**City of Portland, Maine - Building or Use Permit Application**  
389 Congress Street, 04101 Tel: (207) 874-8703, Fax: (207) 874-8716

Permit No: 04-0038 Issue Date: JAN 26 2004 BL: 061 A004001

Location of Construction: 383 Spring St	Owner Name: Horn Eckart &	Owner Address: 383 Spring St	Phone: CITY OF PORTLAND
Business Name:	Contractor Name: no contractor / self	Contractor Address: Portland	Phone:
Lessee/Buyer's Name	Phone:	Permit Type: Additions - Dwellings	Zone: R-4

Past Use: two family	Proposed Use: two family - interior renovations - build interior stairway	Permit Fee: \$84.00	Cost of Work: \$7,000.00	CEO District: 2
Proposed Project Description: build interior stairway		FIRE DEPT: N/A <input type="checkbox"/> Approved <input checked="" type="checkbox"/> Denied	INSPECTION: Use Group: R-3 Type: 5B BOCA 1999	
		Signature:	Signature:	
PEDESTRIAN ACTIVITIES DISTRICT (P.A.D.)				
Action: <input type="checkbox"/> Approved <input type="checkbox"/> Approved w/Conditions <input type="checkbox"/> Denied				
Signature: _____ Date: _____

stair section 1
3/16"=1'-0"

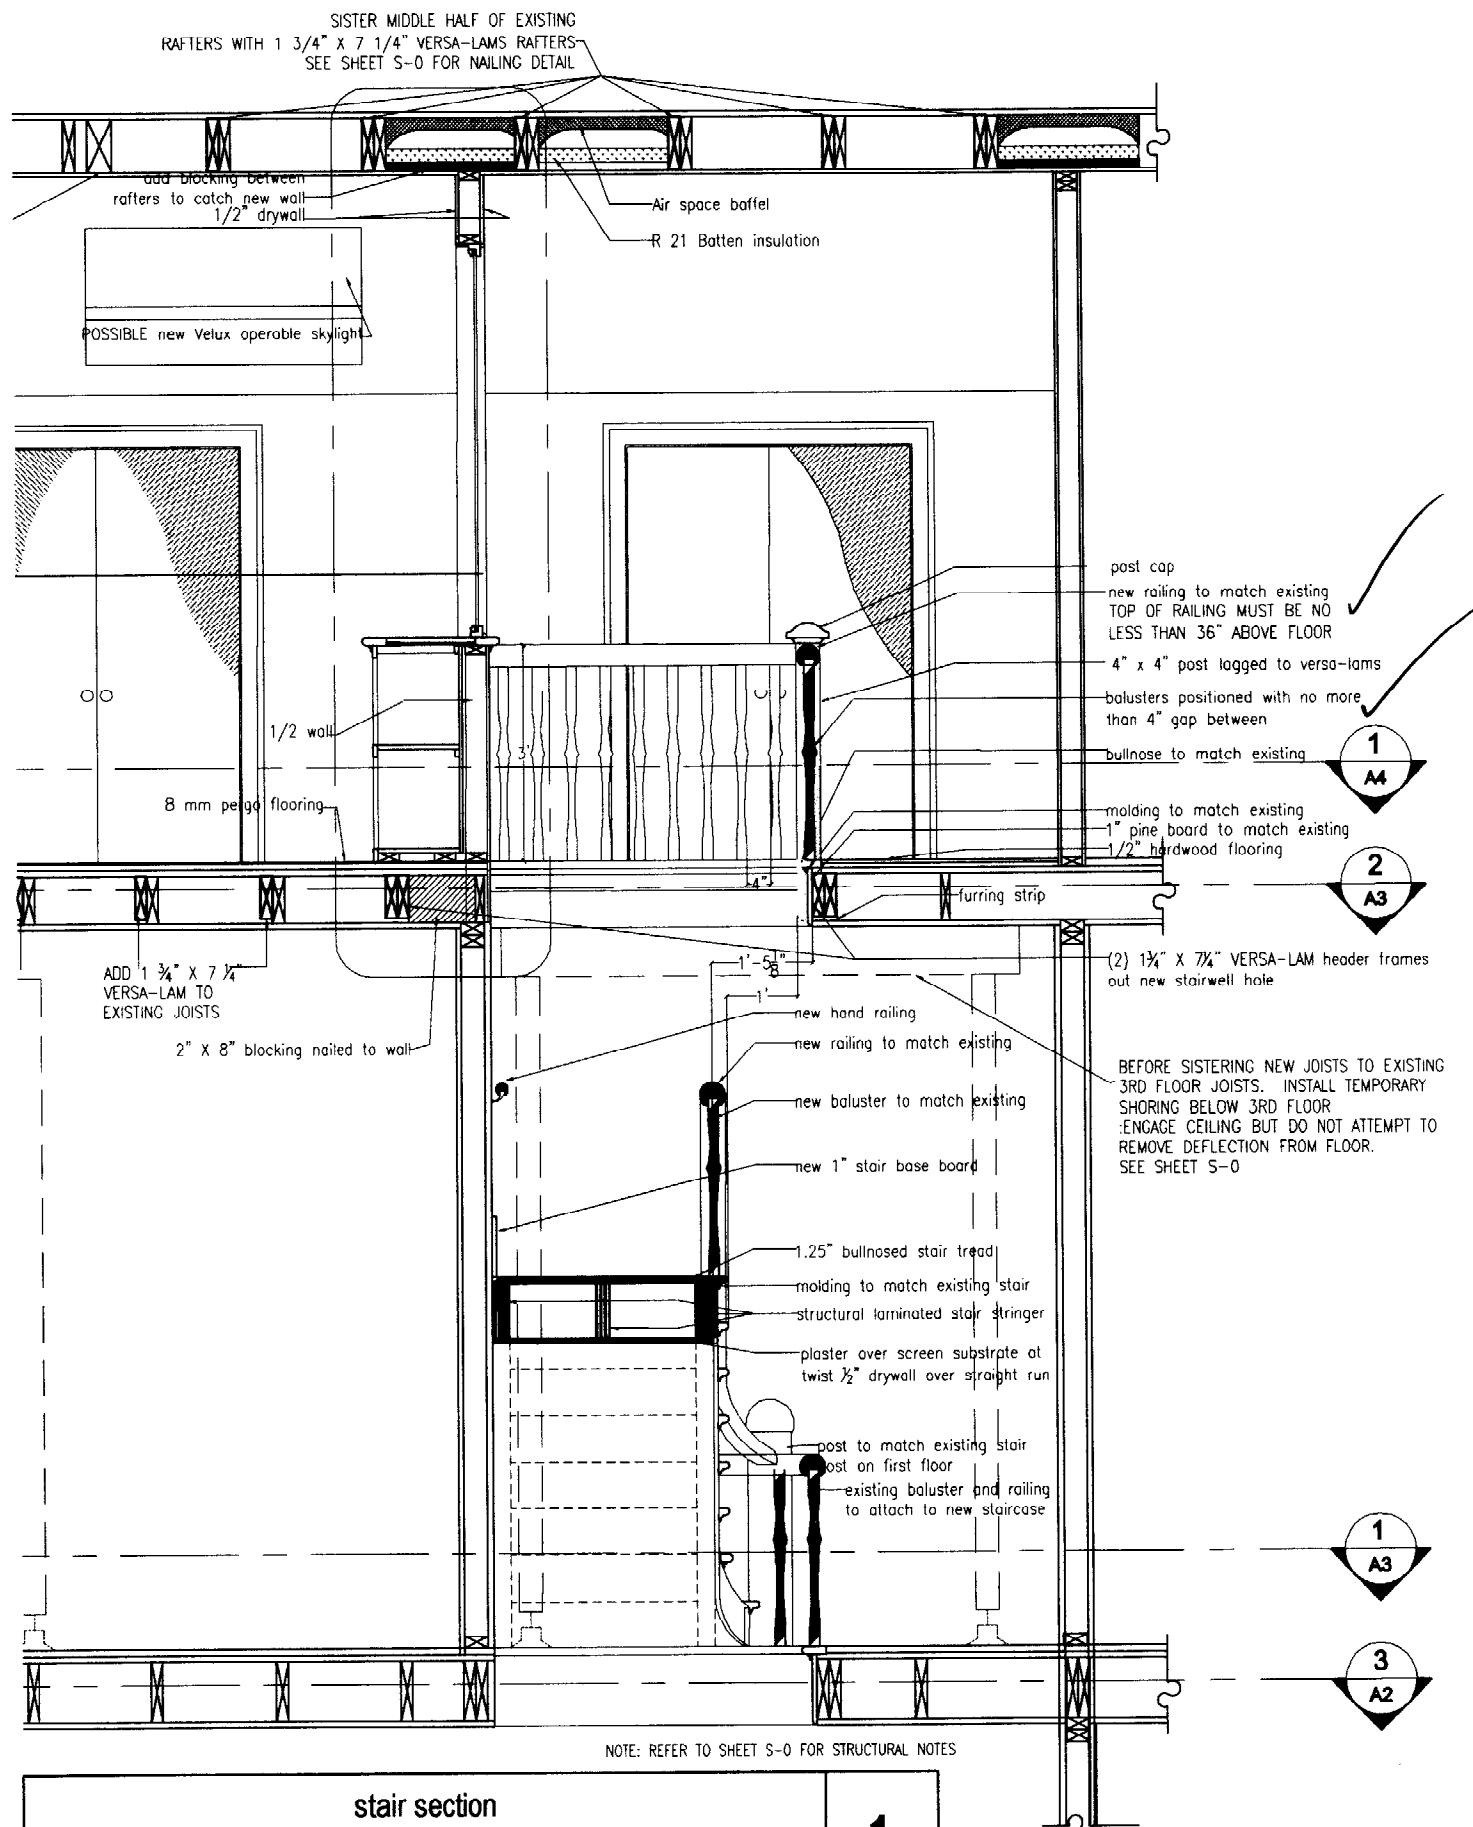
<b>Dept:</b> Building	<b>Status:</b> Approved with Conditions	<b>Reviewer:</b> Tammy Munson	<b>Approval Date:</b> 01/23/2004
<b>Note:</b>			<b>Ok to Issue:</b> <input checked="" type="checkbox"/>
1) As discussed during the review process, the guardrails on the stairs will be 36" minimum measured from the leading edge of the tread.
